USYD-ETP

DPIE Submission – SSD 8636 Modification 2, 18 September 2020

The University of Sydney (the “University”) has reviewed the City of Sydney’s comments in their letter to DPIE dated 3rd September 2020. The University provides the following detailed response. The response is to be read in conjunction with the following attachments enclosed:

Proposed Tree Canopy Coverage

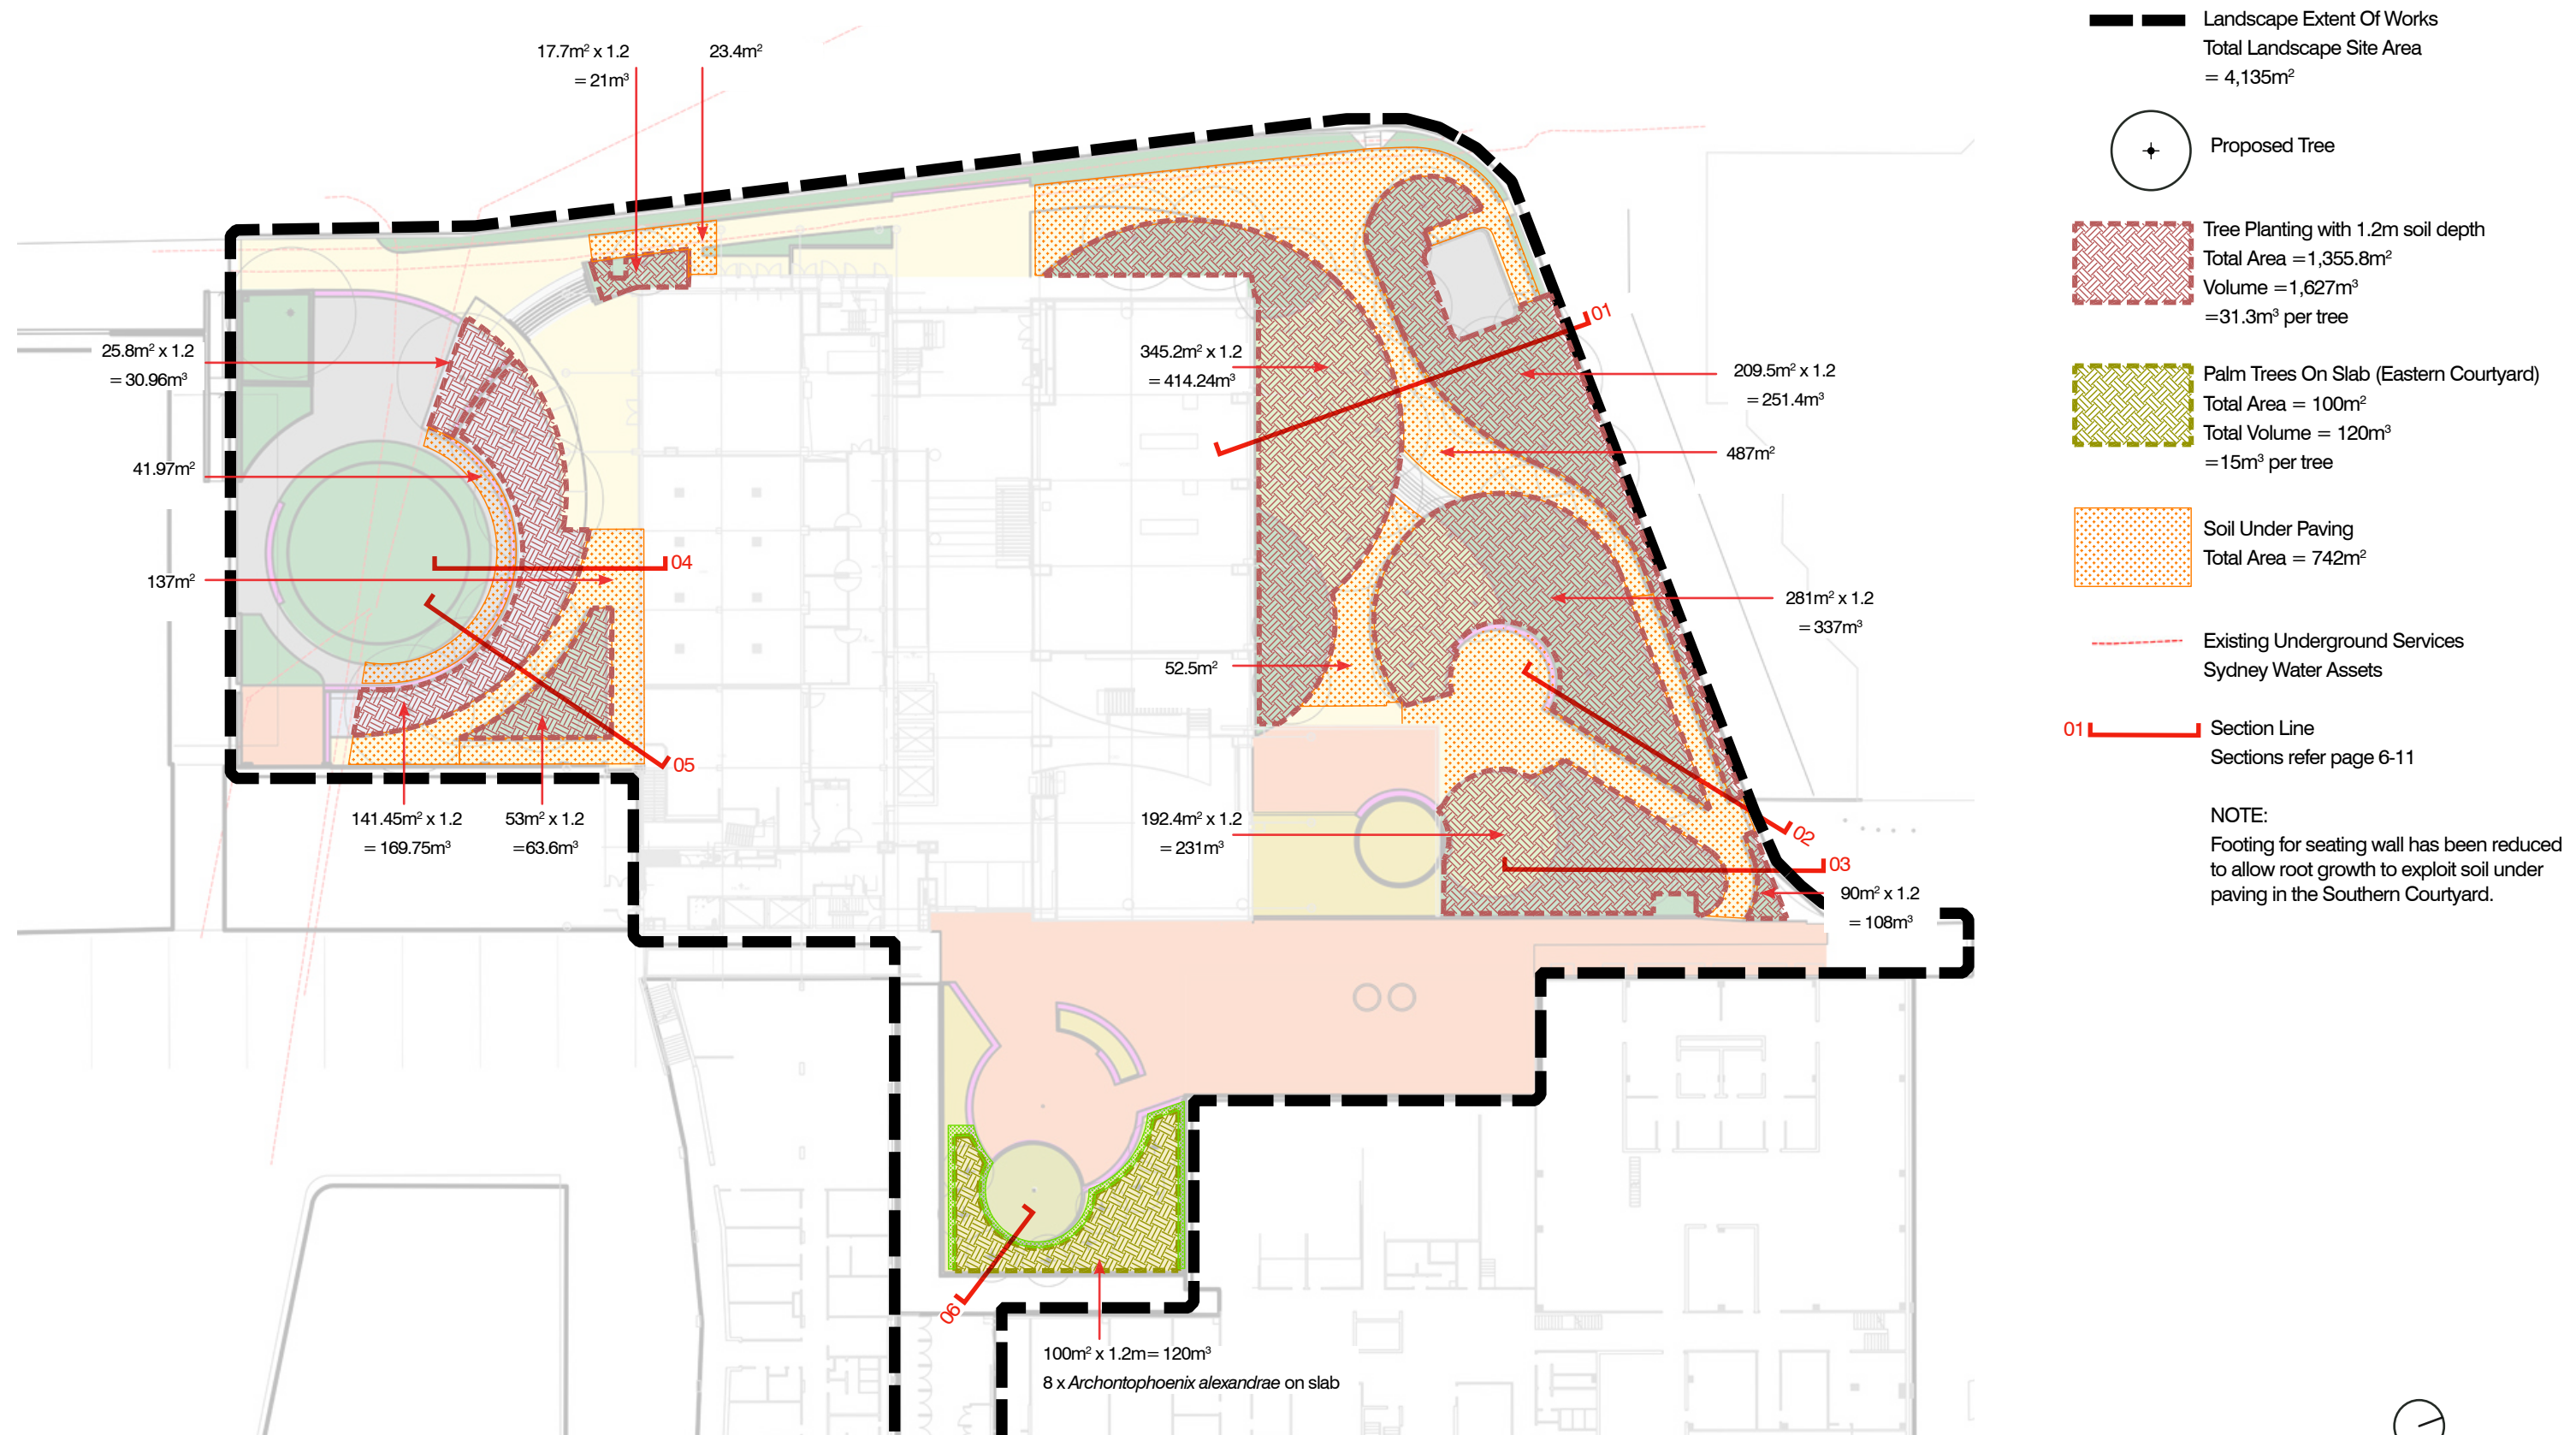
The proposed tree species within the northern landscaped area are predominantly small to medium sized trees that would reach a mature height of 10 metres. The City recommends larger canopy trees with a minimum mature height 15 metres are provided to achieve the 15% canopy coverage in accordance with the Sydney DCP 2012. The proposed raised tree planters on slab will not provide adequate soil depth to support healthy tree growth and do not comply with the Sydney Landscape Code. Consideration must be given to adequate soil availability and space (above and below ground) for all tree species to reach their full genetic potential.

Refer to the **Proposed Tree Canopy Cover** plan of revised tree species and increased quantities. We can confirm the proposed combined tree canopy will achieve over 36% coverage within 10 years after the project completion. This is in compliance with min. 15% canopy coverage required in the Sydney DCP 2012.

Based on input from the project's independent arborist (treeIQ), all nominated trees have the potential to reach a 15m mature height – refer table in figure 7 below. With accumulated mature canopy coverage of more than 36% against the overall project site. An additional 8 trees have been added to assist in providing additional shade and natural amenity into the site.
